COUNTY COUNCIL'S RESPONSE TO CONSULTATION ON THE FOLLOWING DEVELOPMENT PROPOSAL

Application no: 20/03660/REM

Proposal: Reserved matters application to 18/02147/OUT - Erection of 21 dwellings (consideration of Appearance, Landscaping, Layout and Scale)

Location: Stone Pitts, Hempton Road, , Deddington, Oxfordshire,

DRAWING TITLE:  
PLOTS 15-18  
PLANS AS PROPOSED

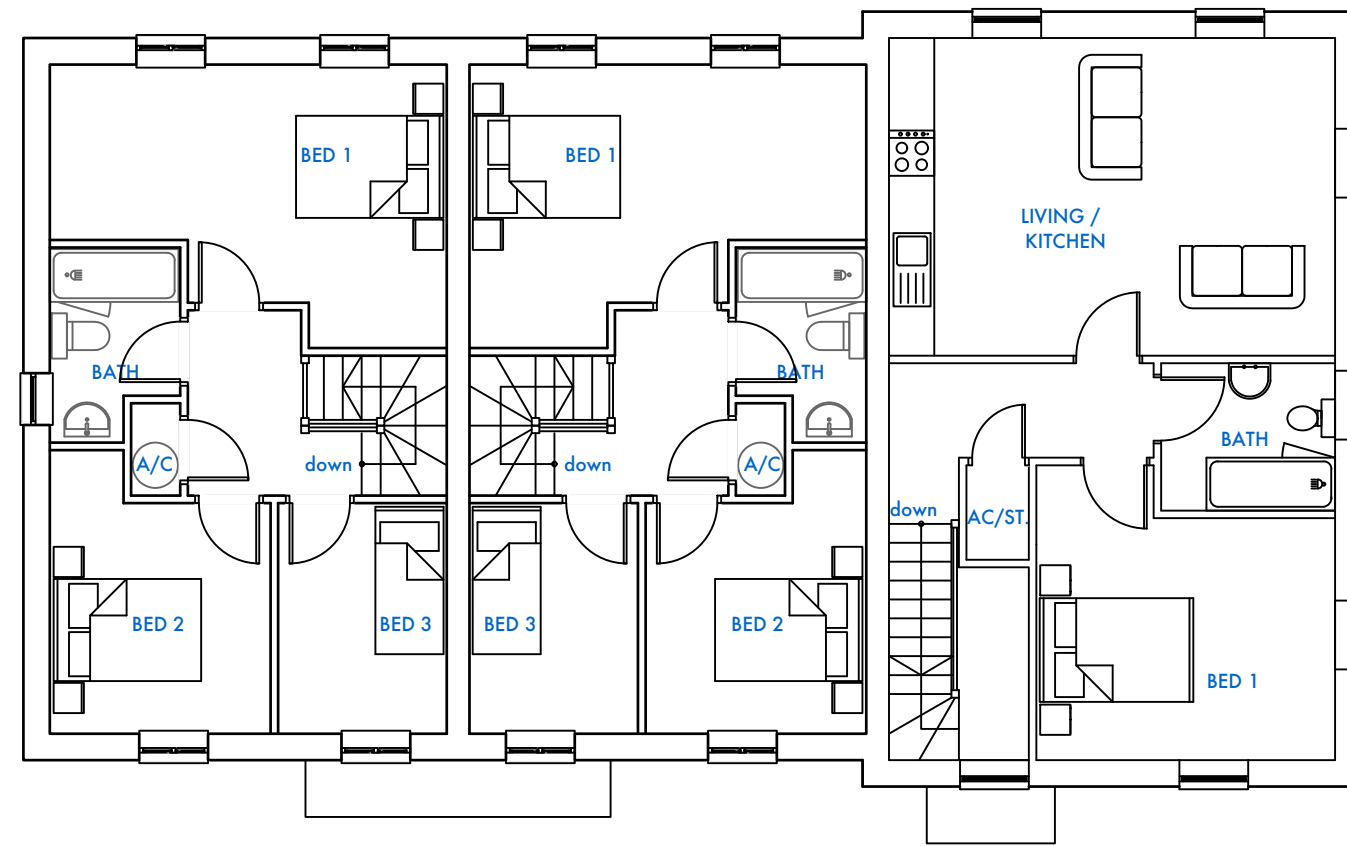
- **Cycle Parking**
Before the development permitted is commenced details of the cycle parking areas, including dimensions and means of enclosure, shall be submitted to, and approved in writing by, the Local Planning Authority. the approved Cycle areas shall thereafter be retained solely for the purpose of the parking of cycles.
Reason: To encourage the use of sustainable modes of transport in line with policy M5.
